From: [Hutton, Trevor \(ECY\)](#)
To: [Jeremiah Cromie](#); [Candie Leader](#); [Melissa Schumaier](#); [Holly Erdman](#); [Jesse Cox](#); [Roberts, Tyler \(ECY\)](#); [Clear, Gwen \(ECY\)](#); [White, Lori \(ECY\)](#); [Rich Elliott](#); [Pat Nicholson](#); rusj461@wcy.wa.gov
Cc: [Jeremy Johnston](#)
Subject: RE: LP-08-00024 Wildcat Plat Follow-up comments?
Date: Tuesday, July 27, 2021 4:28:51 PM

MEMORANDUM

SUBJECT: Wildcat Plat LP-08-24 – Updated Comments

WILDCAT PLAT
PORTION OF SECTION 32, T. 18N., R. 19E., W.M.
KITITAS COUNTY, STATE OF WASHINGTON

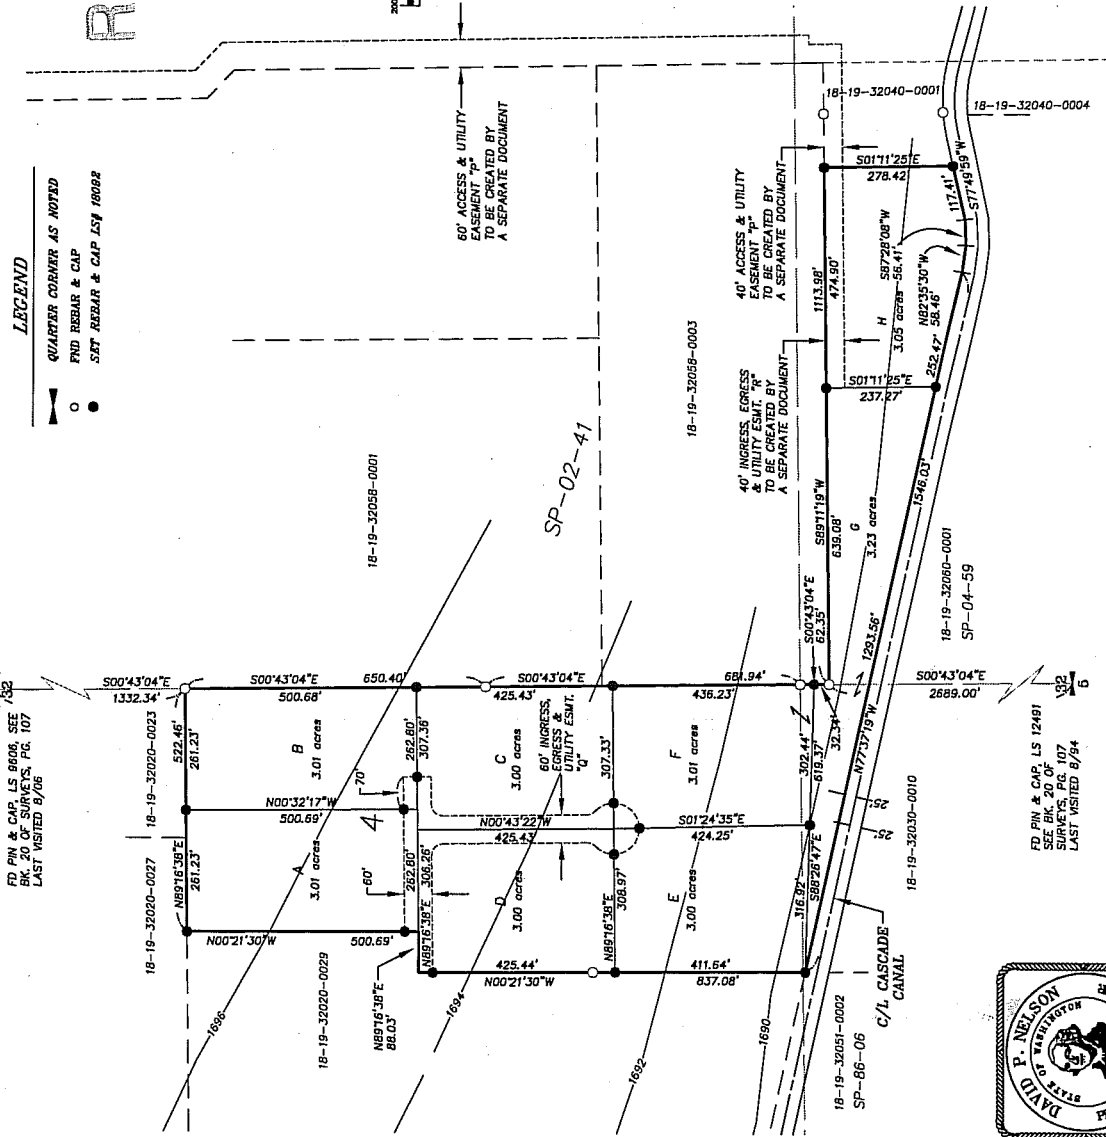
This Short Plat has been held up for 13 years due to development problems. Comments below reflect the need to update the Plat to current information.

1. For the 60' access easement, please show public access (including recording numbers) of easements to a public right of way.
2. The Plat will need to be stamped and signed by a surveyor actively licensed in the State of Washington.
3. Adjacent property owners list will need to be updated.
4. Current title report will need to be provided and reviewed prior to final approval.
5. The owner will need to be updated on the face of the plat.
6. The access easement over lots A through F will need to have radii dimensions shown.
7. Some dimensions are obscured by crossing linework.
8. The contact information for the survey firm will need to be updated.

Of Note: It is assumed that the corners shown as found, but do not have dimensions shown to tie them are NOT part of any survey control network utilized to determine the boundaries as shown.
